PLANNING AMENDMENT

APPLICANT NAME AND ADDRESS MR & MRS S GILBY 7 BARBERS DRIVE SOUTH CROWLAND Lincs PE6 0EY Telephone:	AGENT NAME AND ADDRESS JULIAN WARRICK 8 BEECH GROVE EDNINGTON Lincs DN11 4XR. Telephone: 01775 820123
SITE ADDRESS DETAILS AS APPLICANT ADDRESS	
CURRENT APPLICATION NO: This amendment cannot be considered unless the relevant reference is stated.	H02-0760-20
Building Regulation reference relating to same development (if applicable)

FULL DESCRIPTION OF DEVELOPMENT OF CURRENT APPLICATION THAT THIS AMENDMENT RELATES TO	PROPOSED 2 STOREY EXTENSION & ALTERATIONS INC. DETACHED GARAGE.
--	---

J136-PL 2A

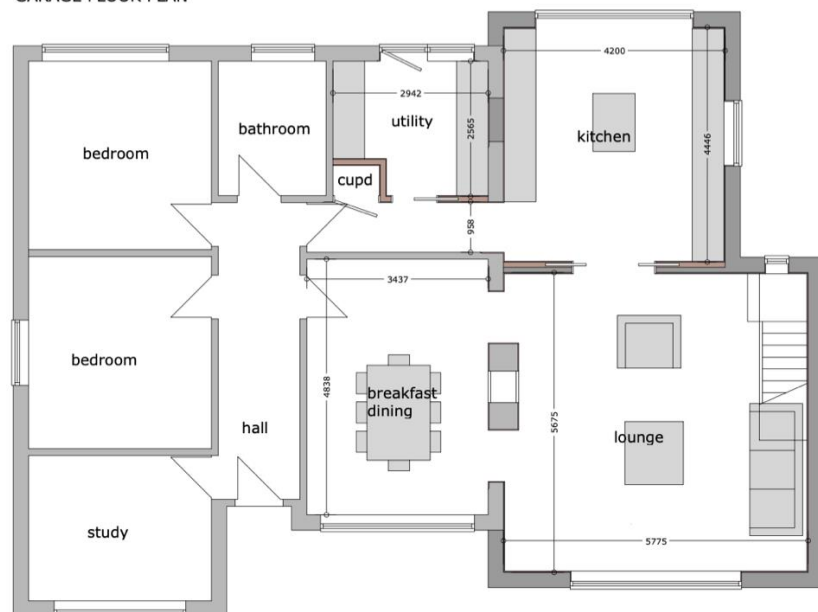
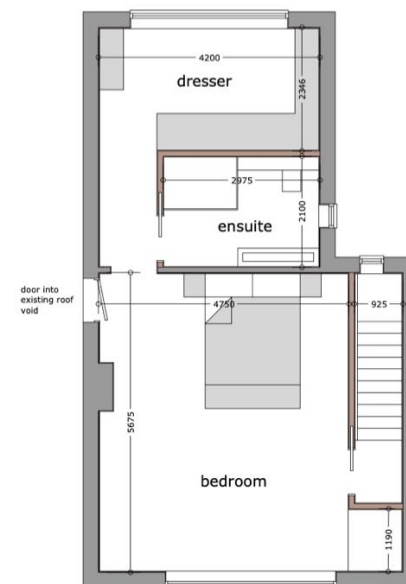
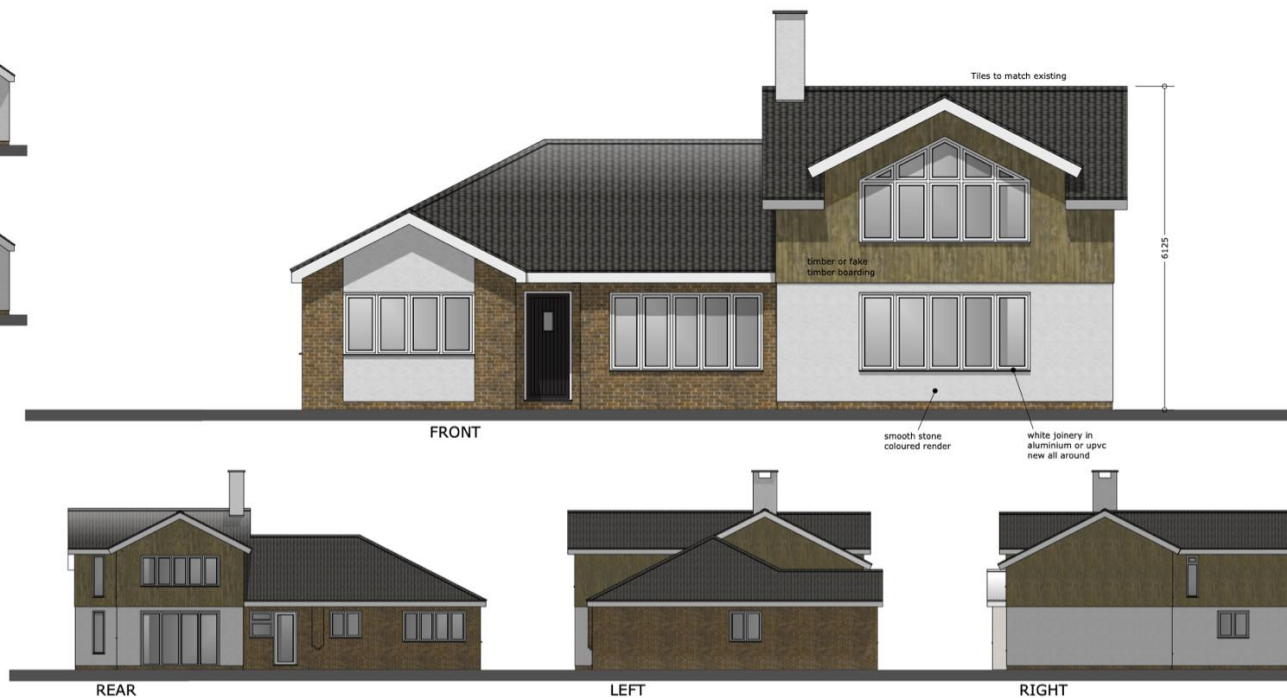
State details of amendments proposed. (Give a full detailed list of the changes, and also mark these clearly on the accompanying plans. Only the changes listed here will be considered)	ADDITIONAL DIMENSIONS ADDED TO GARAGE ON SITE PLAN & HEIGHT SHOWN TO EXTENSION.	
State drawing numbers of the current submission	Jr36 - PL 1, 2 & 3.	
Has this amendment been requested by the Council? (If so, state Officer dealing with the application)	YES/ NO	MARIA SALEMME.
Describe any part of the original development which is excluded by virtue of the amendment, and state any alteration to plot numbers		
Has a similar amendment been submitted under Building Regulations? (If so, state Building Control Surveyor dealing with application)	YES/ NO
